## DELEGATED HOUSEHOLDER DECISION

<b>Item No.</b>	<b>Report of the Head of Development Management and Building Control</b>		
<b>Address:</b>	63 WOODLANDS AVENUE RUISLIP		
<b>Development:</b>	Erection of a rear single-storey extension and installation of an accessibility handrail and ramp on the frontage.		
<b>LBH Ref Nos:</b>	79366/APP/2025/773		
<b>Drawing Nos:</b>	63P001 63SP001/02 63FP_PP001/01 63FP_EX001 63EL001/01 63EL_002/02		
<b>Date Plans received:</b>	19-03-25	<b>Date(s) of Amendments(s):</b>	02-05-25 25-04-25
<b>Date Application valid</b>	19-03-25		28-03-25 02-05-25 02-05-25

DWG NO/REV : 63EL_002/02

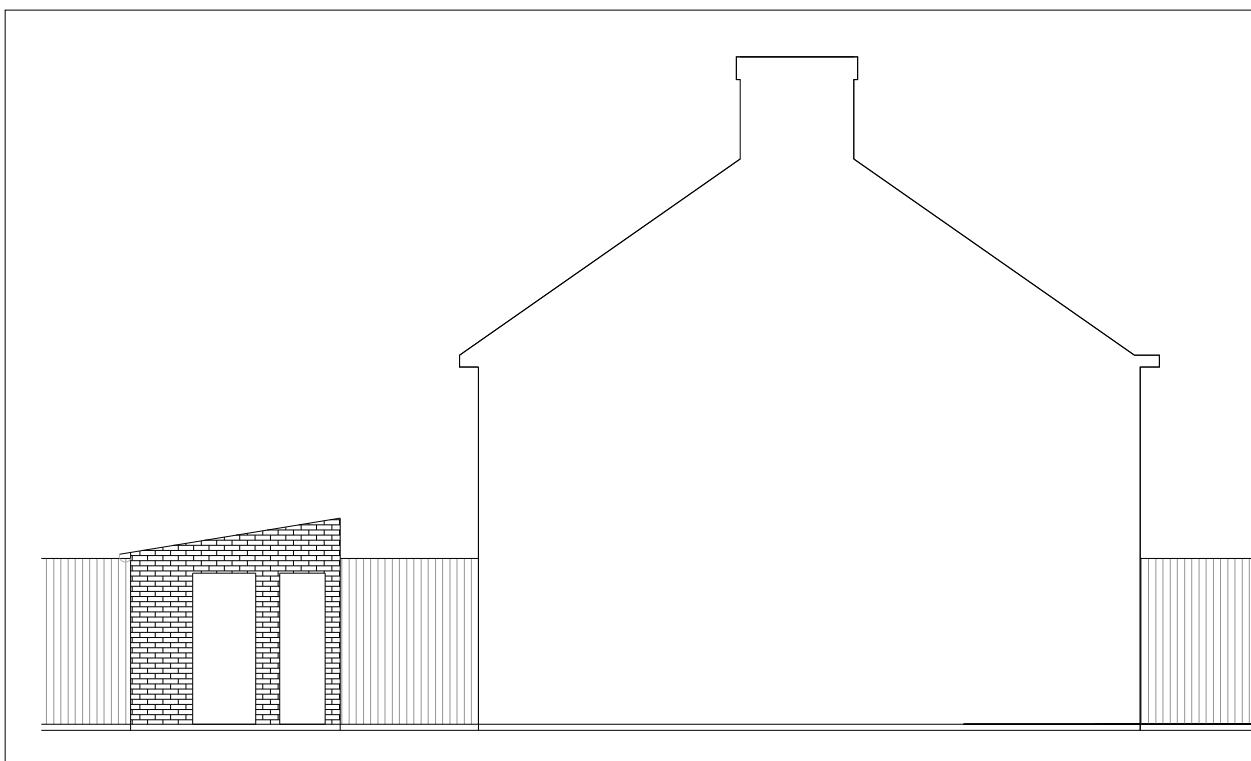
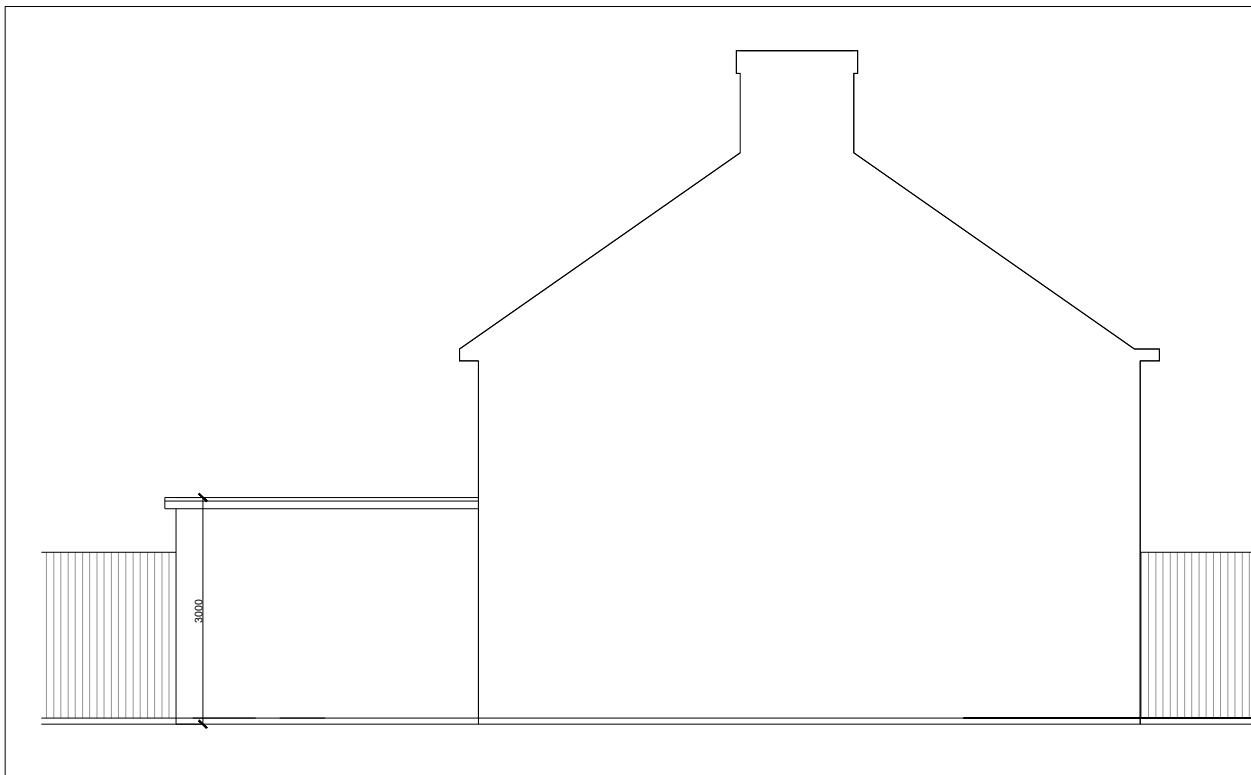
The height of the single-storey flat-roofed extension is approximately 2m, which is in accordance with Policy DMHD 1 and is therefore acceptable.

No.61. On balance, this depth of intrusion would not unduly harm the outlook of No.61 and would not be a sufficient reason for refusal. The proposed 3m height is appropriate for a single-storey extension, and an adequate level of daylight and sunlight access would be maintained for the rear of No.61, avoiding undue bulk, dominance, or daylight effects over the neighbouring property. No side-facing windows are proposed to face No.65, avoiding any direct overlooking or undue privacy impacts.

DWG NO/REV : 63SP001/02

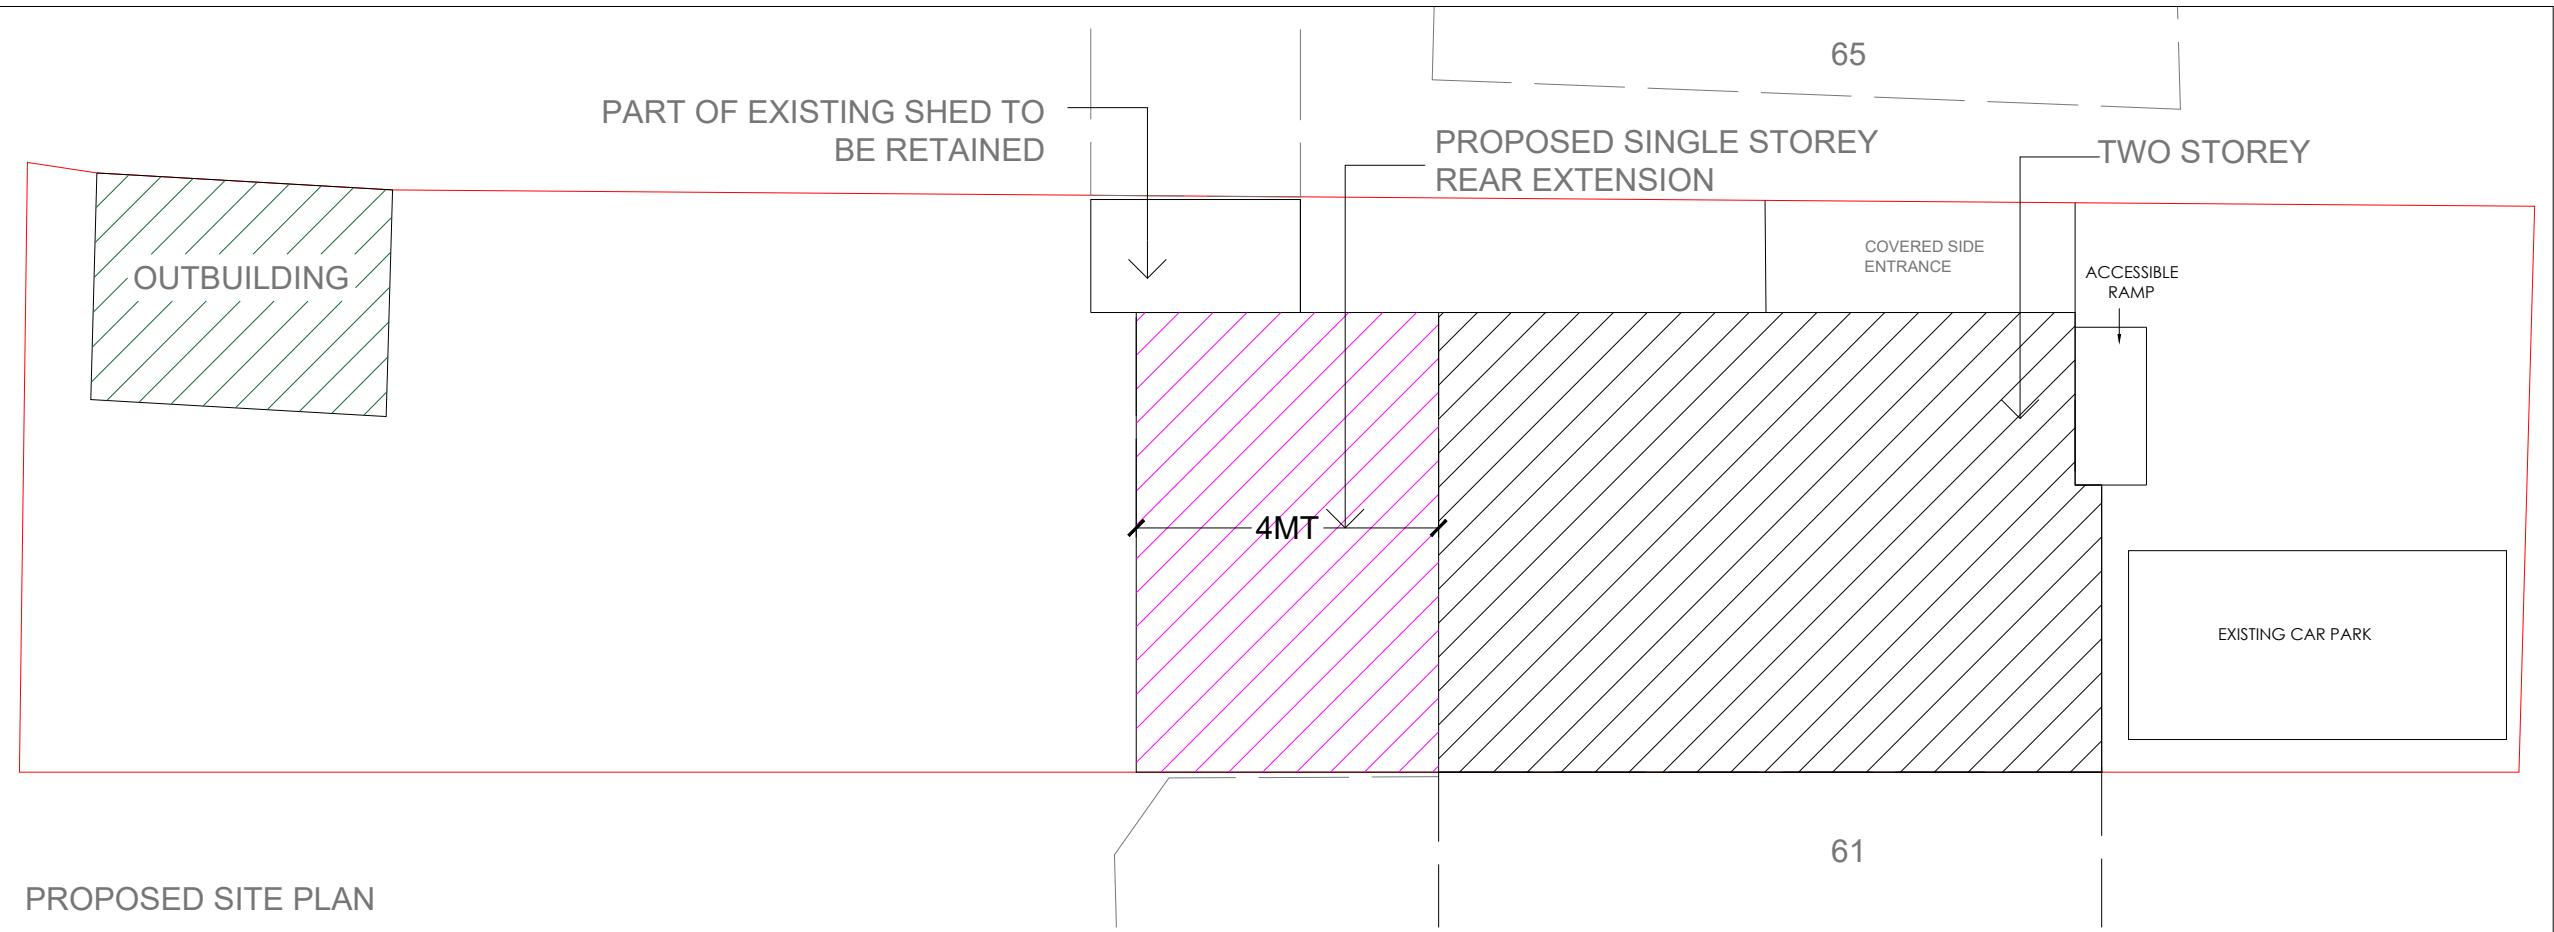
The originally submitted scheme proposed a deeper rear extension with a depth of 4.6m from the rear building line, along with a wraparound side extension. The applicant was advised that the 4.6m depth would not be supported by the Local Planning Authority due to harm to the character of the area and undue harm to the residential amenities of neighbouring properties. The applicant subsequently submitted an amended scheme with a reduced depth of 4m and the side extension omitted. This amended scheme is assessed below.

While the rear depth of the extension would still exceed the guidance set out by Policy DMHD 1, it would be shorter than the rear building line of the existing shed outbuilding and, therefore, would be similar in effect to the existing built environment. Further, the extension would not be readily visible from the street frontage, and there are examples of similar depth extensions nearby, such as at 84 Woodlands Avenue and 38 and 45 Warren Drive. On balance, given the site's context, the depth of the extension is therefore not considered a sufficient reason for refusal, particularly as the extension would not unduly harm the residential amenities of neighbouring properties for the reasons laid out below.

The proposal would not unduly harm the residential amenities of the occupiers of 61 Woodlands Avenue. The depth of the extension would extend approximately 400mm past the rear extension of

The proposal would not unduly harm the residential amenities of the occupiers of 65 Woodlands Avenue. The proposed extension would be setback from the shared side boundary with No.65, avoiding any undue bulk, dominance, or daylight effects over the neighbouring property. The depth of the extension would also be shorter than the existing shed located along the shared boundary and, therefore, would not introduce any new notable impact to the outlook of the adjacent dwelling. No side-facing windows are proposed to face No.65, avoiding any direct overlooking or undue privacy impacts.
